WEST SUSSEX COUNTY COUNCIL CONSULTATION

TO:	Arun District Council FAO:Michael Eastham
FROM:	WSCC - Highways Authority
DATE:	6 May 2021
LOCATION:	Land At Salt Box West Of Shripney Road Bognor Regis PO22 9NW
SUBJECT:	BE/61/21/DOC Approval of details reserved by condition imposed under hybrid application BE/135/18/PL relating to Full Condition Nos 7 - vehicular link from Salt Box site through to Rowan Park Caravan Park, 8 - car parking & secure cycle parking spaces, 22 - method of storage & disposal of litter & waste including recycling facilities, 23 - footpath connections between Salt Box and Bersted Brooks Local Nature Reserve and Rowan Park Caravan Park, 26 - facilities for storage of oils, fuels or chemicals and 38 - equipment to discharge odours & fumes from cooking process.
DATE OF SITE VISIT:	n/a
RECOMMENDATION:	Advice
S106 CONTRIBUTION TOTAL:	n/a

Full application Conditions 7 & 23 - Vehicular & Pedestrian links to Rowan Park Caravan Site

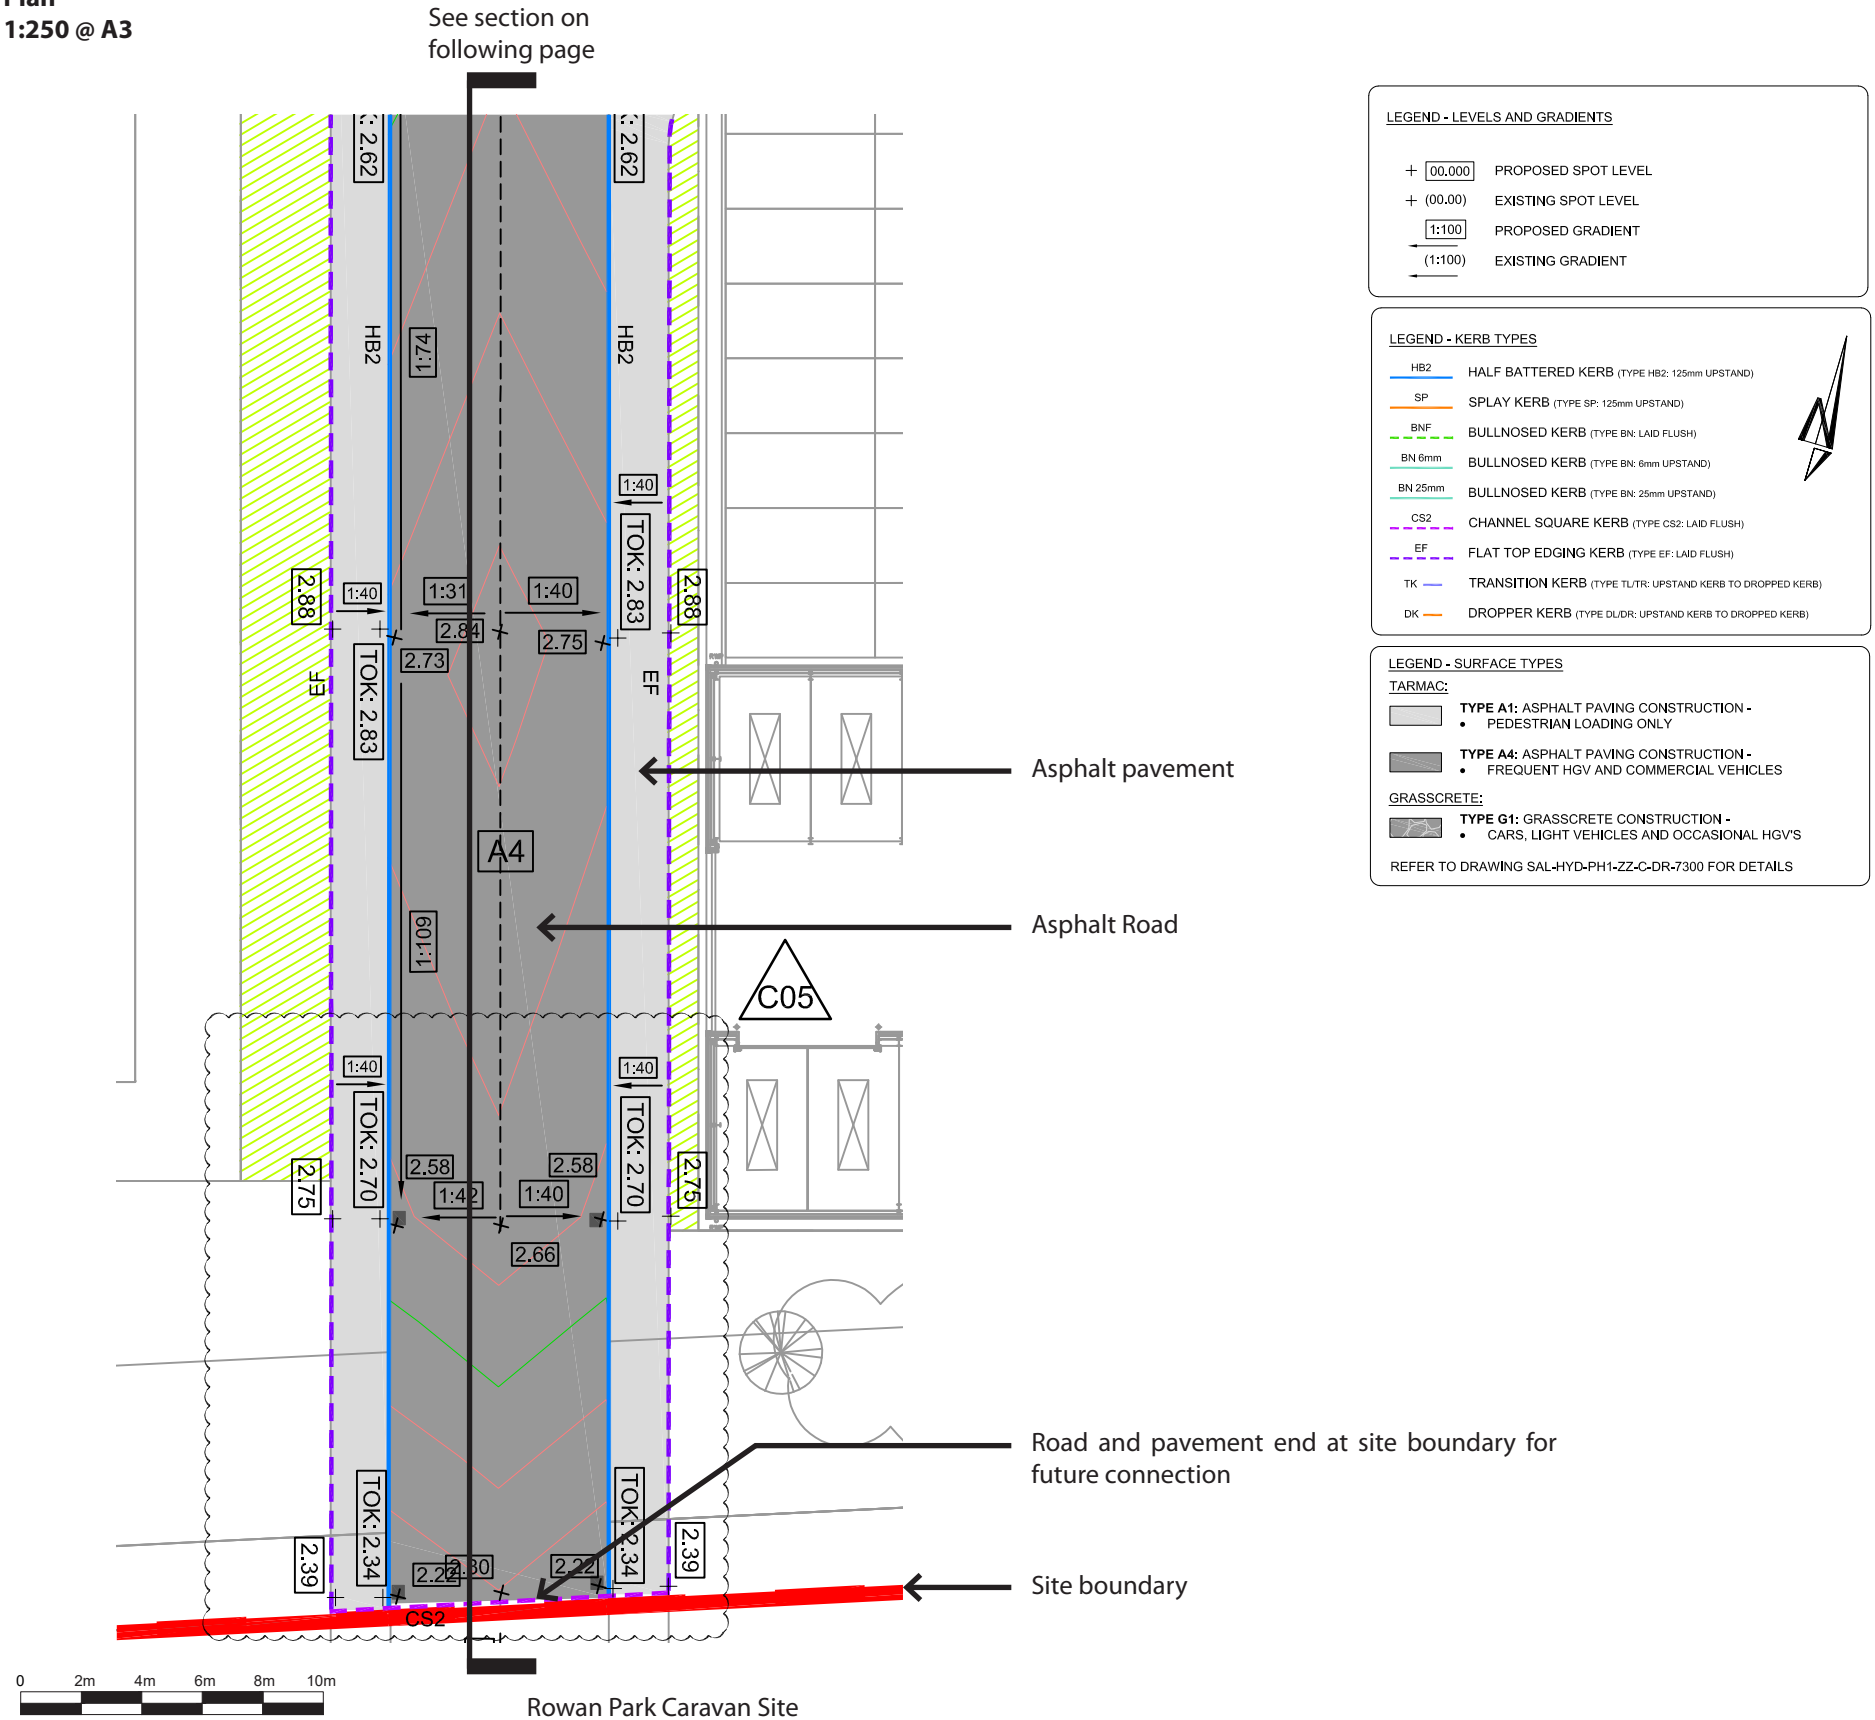
Condition 7 (Vehicular Link to Rowan Park) – Although not requested by WSCC, the purpose and need for the link is understood. The proposed link reflects the nature of the roads proposed within the current planning application and as such is considered to be appropriate to accommodate potential future development at Rowan Park. Based on the details submitted, condition 7 can be discharged.

Full application Condition 8 - Unit 2 Cycle storage

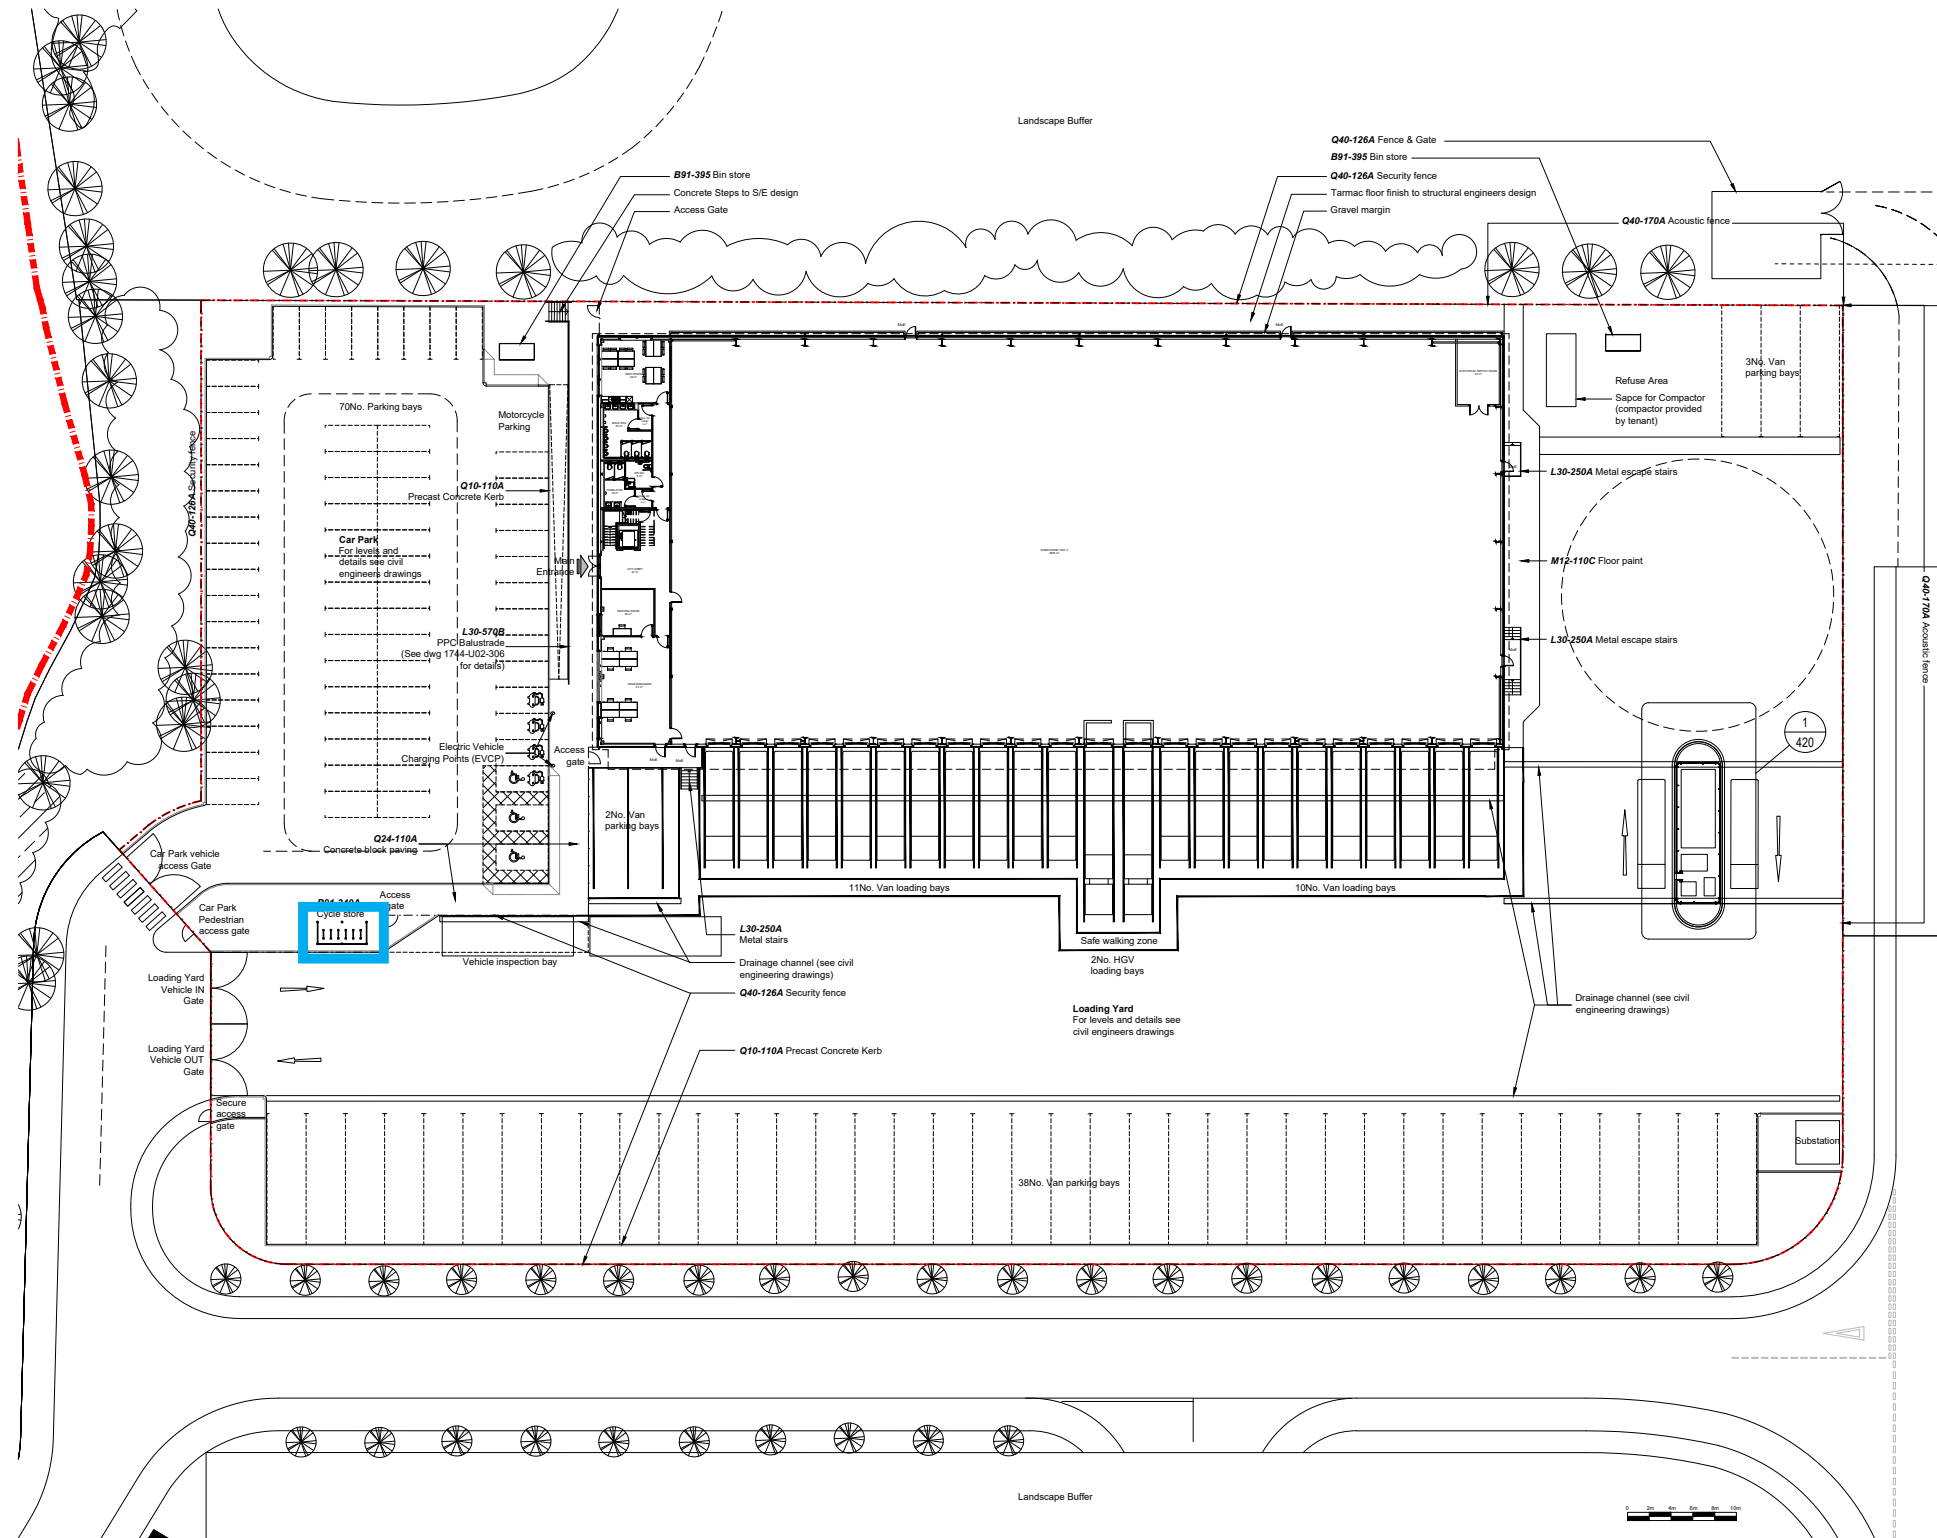
Condition 8 (Car and Cycle Parking) – Details of car parking have already been approved as part of the initial planning permission. No further comments are made in respects of car parking. Details of cycling parking have been provided for units 2, 4, 5, and 8. As such, WSCC are seeking only to agree cycle parking for these units. The details provided are considered appropriate in light of the nature of proposed units. Based on the details submitted, condition 8 can be discharged for units 2, 4, 5 and 8.

Full application Condition 23 - Pedestrian link to Bersted Brooks Nature Reserve

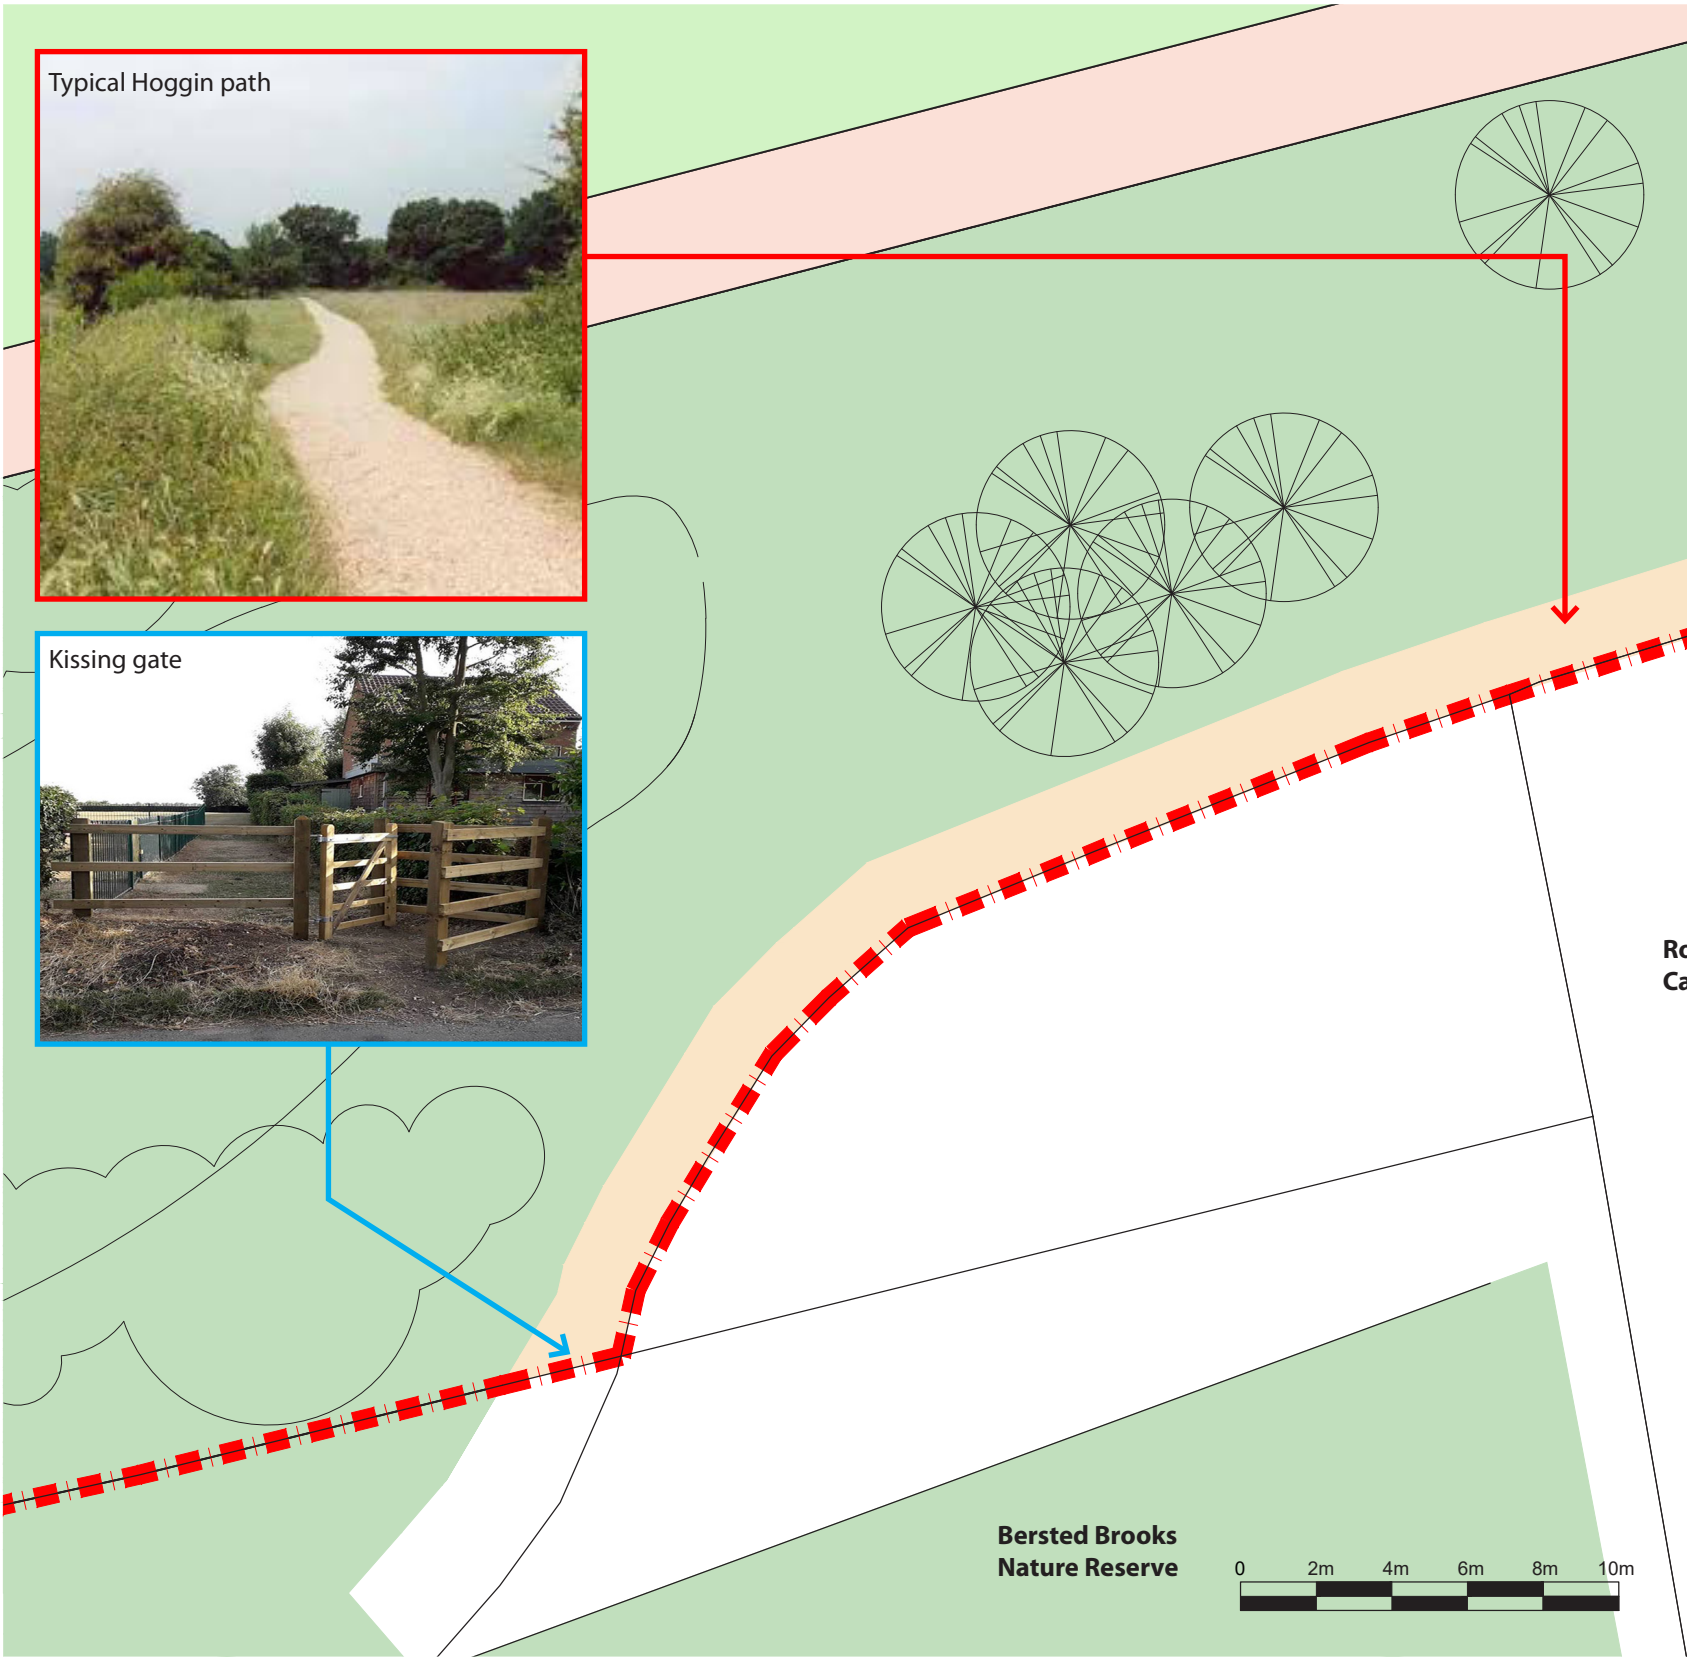
Condition 23 (Provision of a Pedestrian Link to Bersted Brooks) – Again, this condition was not requested by WSCC Highways and it's unclear if the proposed footpath connects with anything beyond the red edge of the application site. Nevertheless, the proposed width and construction of the footpath connection appears appropriate. Based on the details submitted, condition 23 can be discharged.
